Re: Town & Country Planning Act 1990

Application ref: P/~~47/11~~ - 52 East Front Road Pagham

Proposed new extensions 52 East Front Road Pagham

SECTION A-A

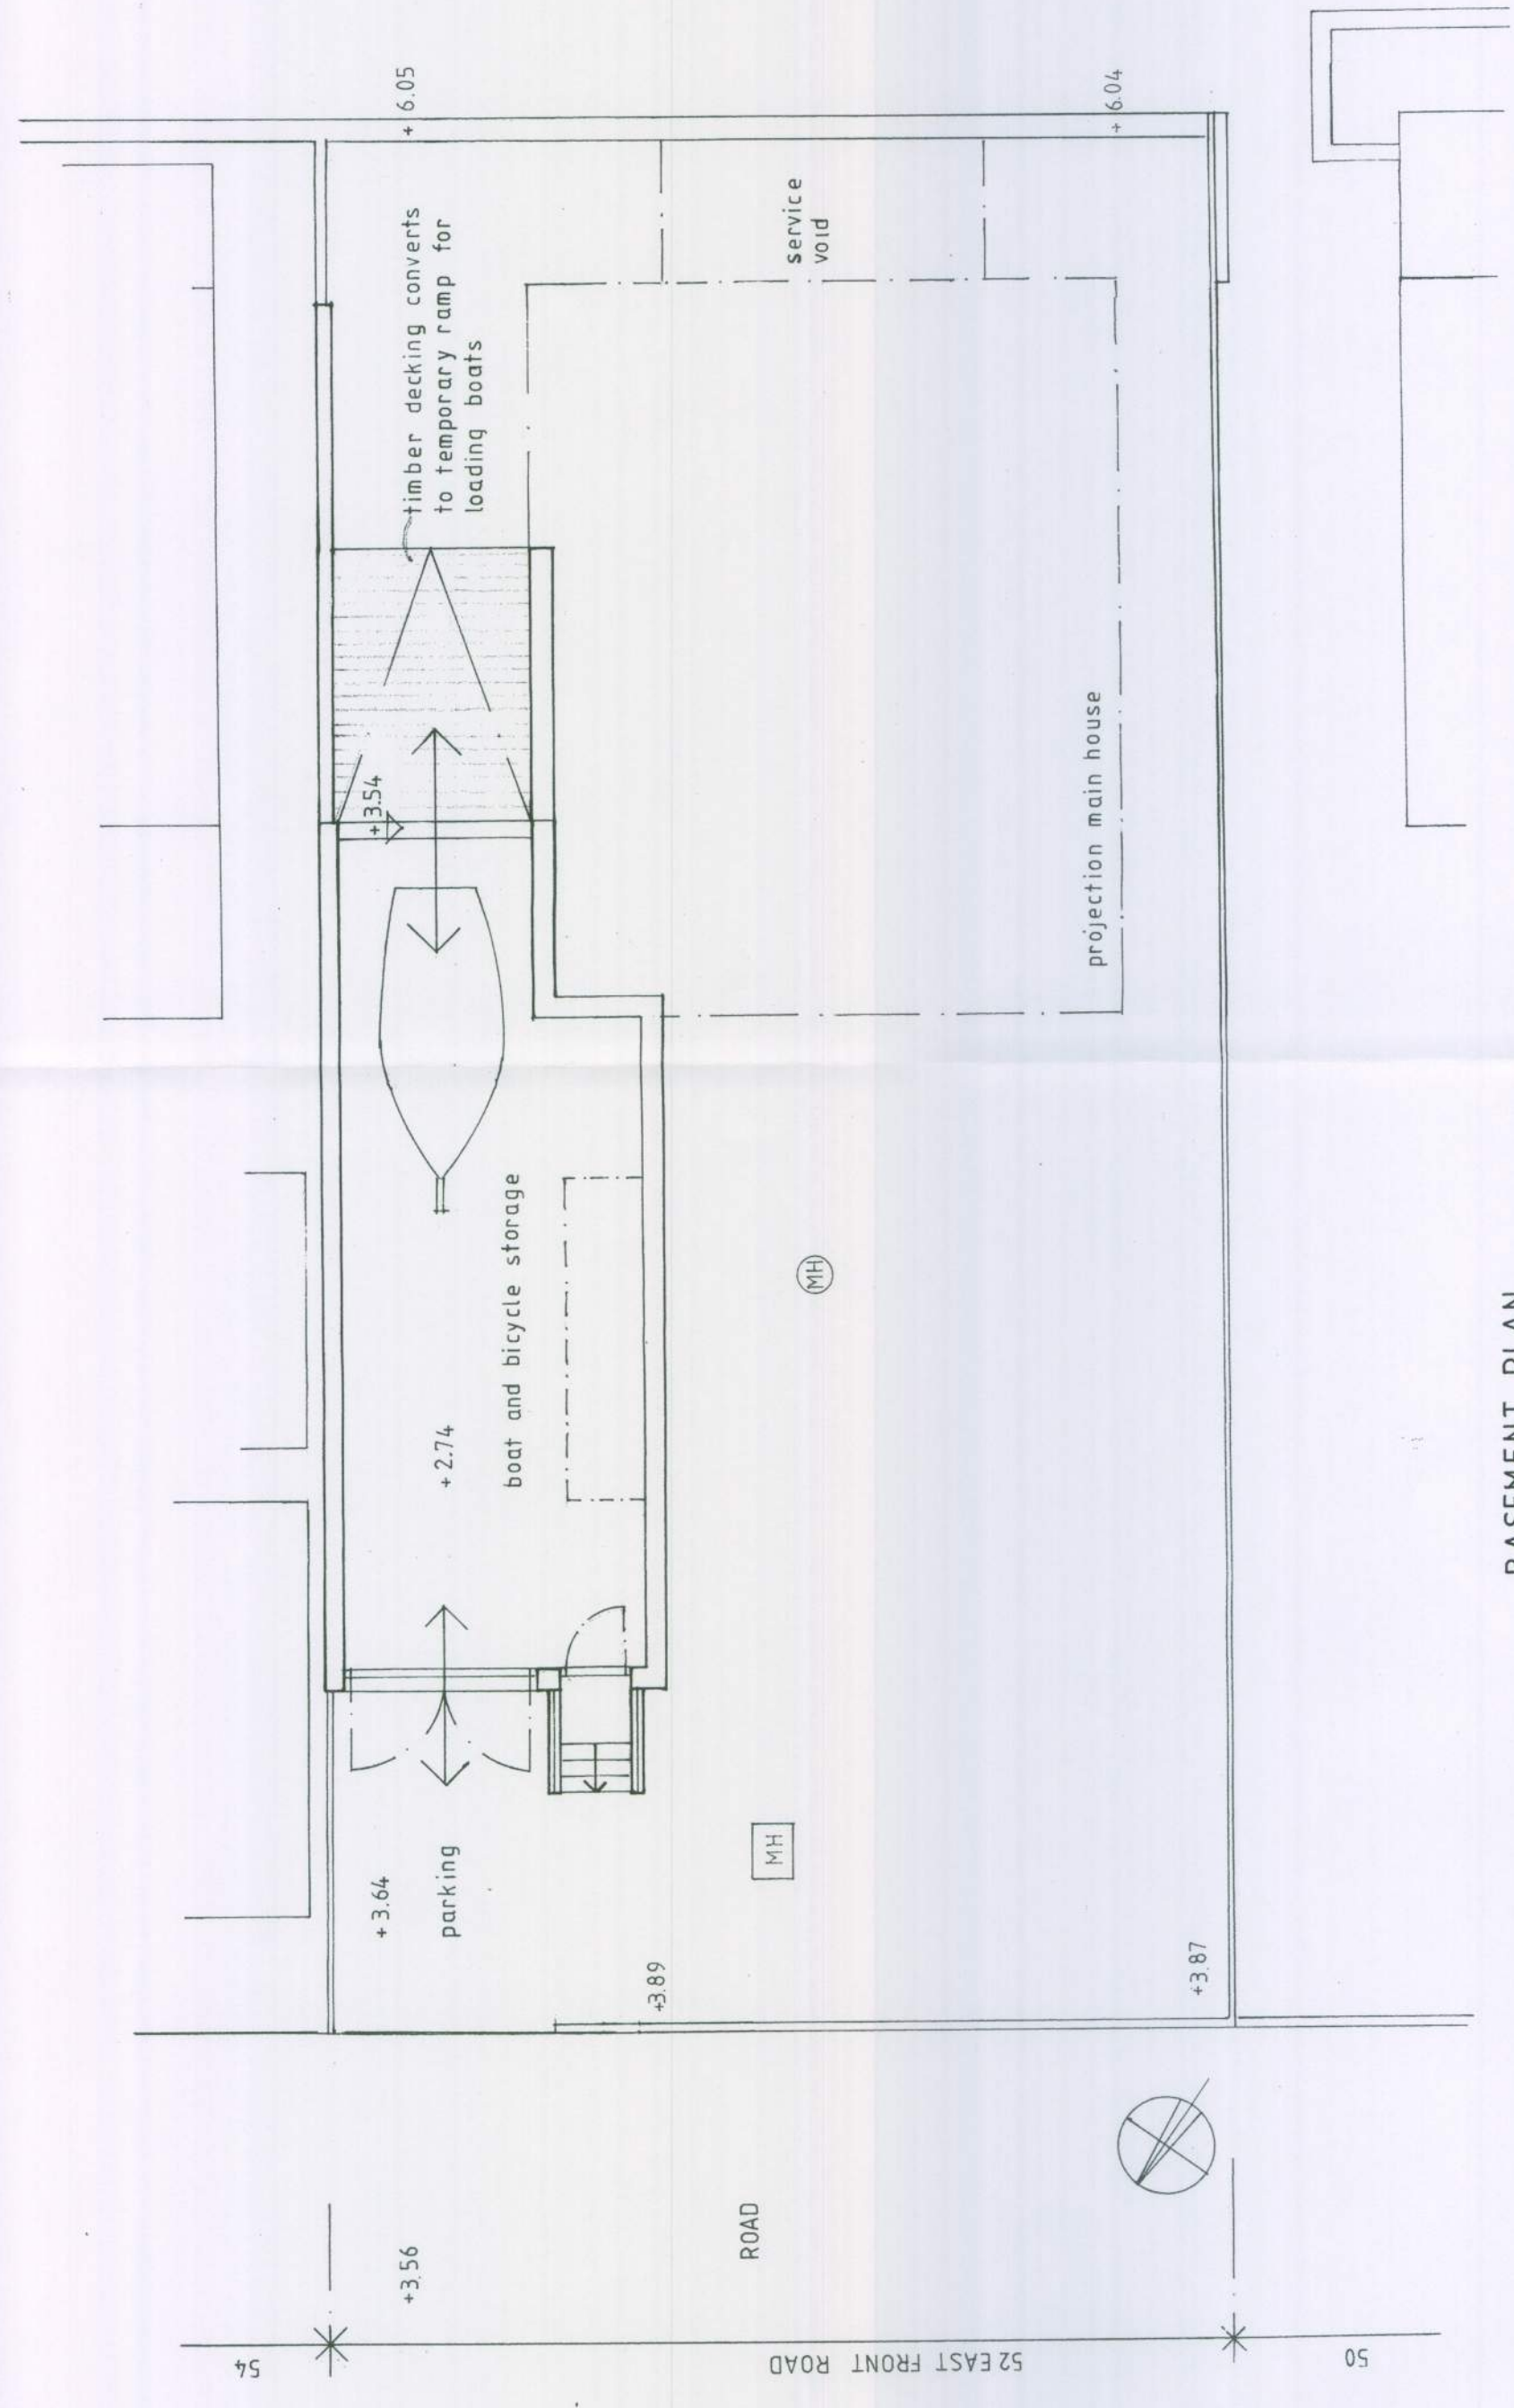
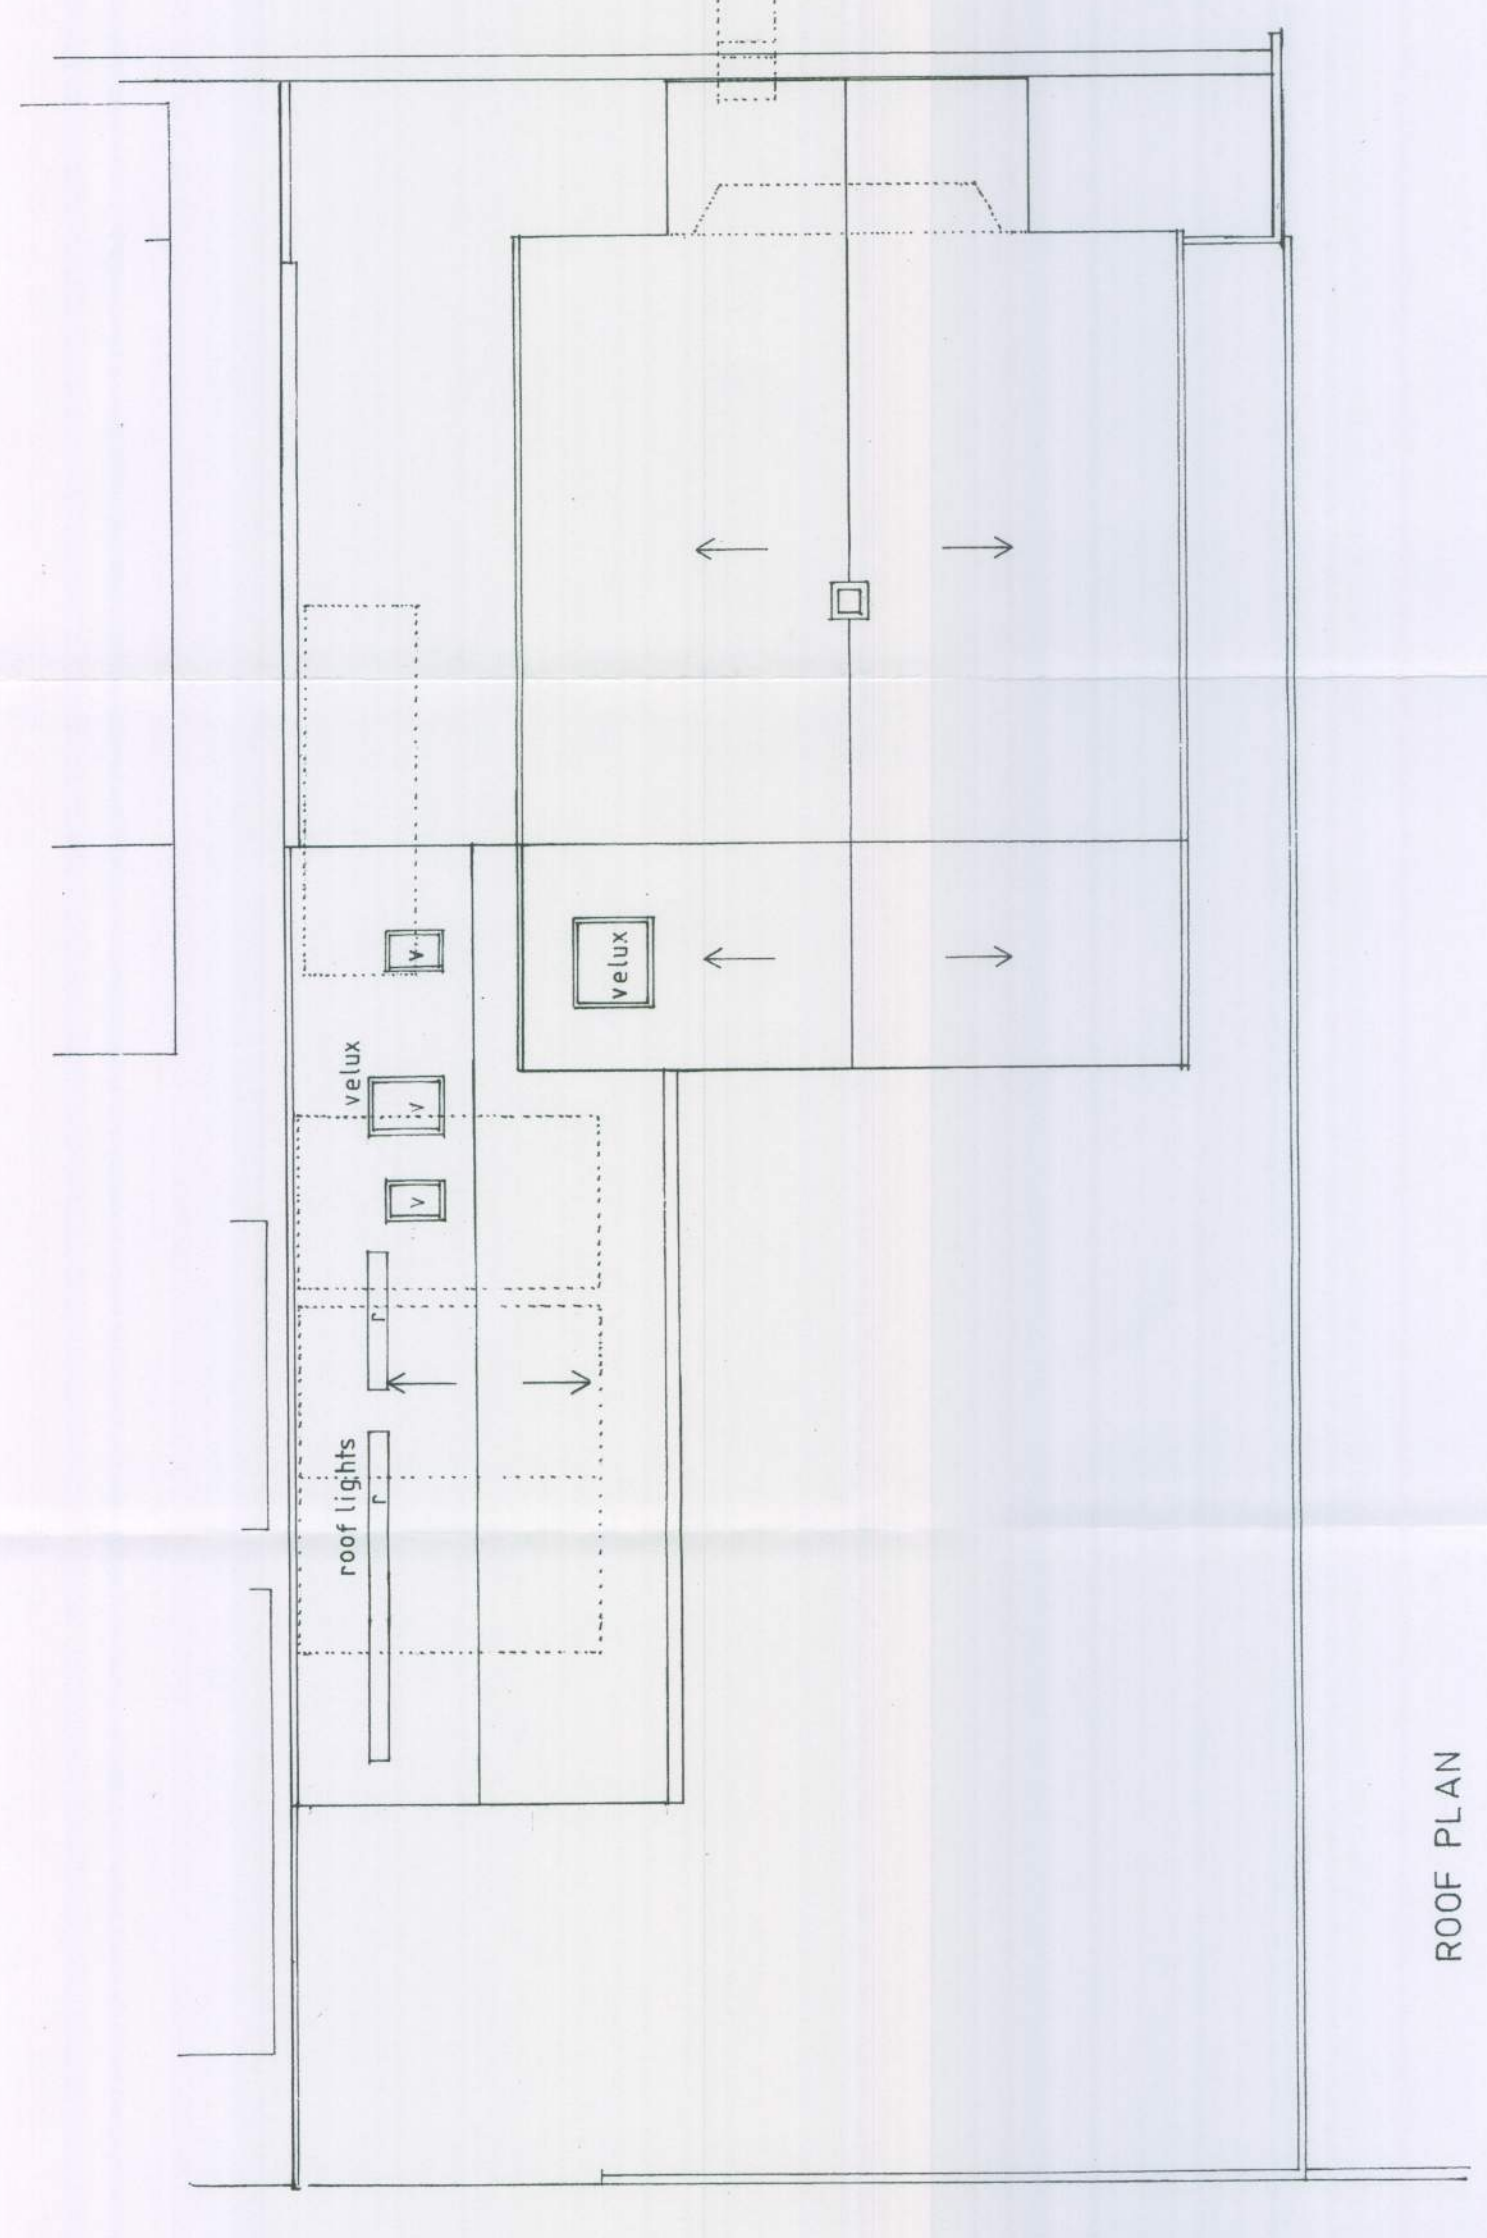
- ii) The proposed construction (no construction details are available to us) has been mooted as timber frame and timber clad. The issue of Fire hazard is therefore of great concern - especially if the Fire break is reduced to 1660mm. Please remember that the prevailing Westerly/North Westerly puts us 1st in line if the proposed extension catches fire. We will be just 1.6 metres to the East which is unacceptable to us- the breezes here on the beach are much stronger than elsewhere locally and the area of SSSI land just the other side of East Front Road is often set fire by visiting children from the caravan park at Church Farm during summer months.

Also, the existing roof material of no.52 is mineral felt ,itself being potentially flammable from flying sparks and especially FIREWORKS and BARBECUES both of which the proposers are frequent participants in. Cladding in timber will require a fireproof paint finish to the exterior of the East flank of the building, which is going to be visually unacceptable to us. Furthermore, we are in the process of fencing the boundary in our own choice and style of timber and colour. The proposers will be therefore unable to service and maintain any paint finish applied to the East flank of their buildings (unless they are built away from the boundary.

We are deeply concerned about subsidence and landslip as the proposed construction is on the boundary just 1660mm from our building. The boundary wall removal is bound to damage our path and our main building is only supported on brick piers on shingle. It is highly likely there will be collateral damage of some sort. From the plans it appears the depth of excavation would need to be in excess of 3 metres in order to facilitate the footings of the below- ground room that is proposed underneath the accommodation floor.

- v) The bulk of the proposal right on the boundary effectively eliminates our view to the west with its trees and hedgerow down to Pagham parade and all the SSSI to the west of us . We will be staring at a blank wall towering above our own fence and obscuring a large part of the evening sunshine which we have enjoyed for the last 27 years since buying our bungalow. The proposer assured us he would keep the height to an absolute minimum. We feel he has reneged on this assurance as he has on others. We are suspicious that the proposed design readily allows for another storey to be build atop of this present proposal using the "verandah" as the ideal site to place the staircase to the 2nd floor. The

- vii) Rainwater gutters and downpipes. None are shown on the plans but no overhang of our vertical boundary of any part of the building or finishes would be acceptable.
- viii) Part of the proposal involves a party wall. No approach has been made to us regarding the necessary handling of this legal matter. Until such legal matters have been notified we cannot agree to any activity which will impinge on our boundary. This project would fall under the Party Wall Act 1996.
- ix) Building to the boundary will effectively prevent us from maintenance to the west side window (now over boarded) and west wall of our garage. Although a small distance from the boundary was achieved - in
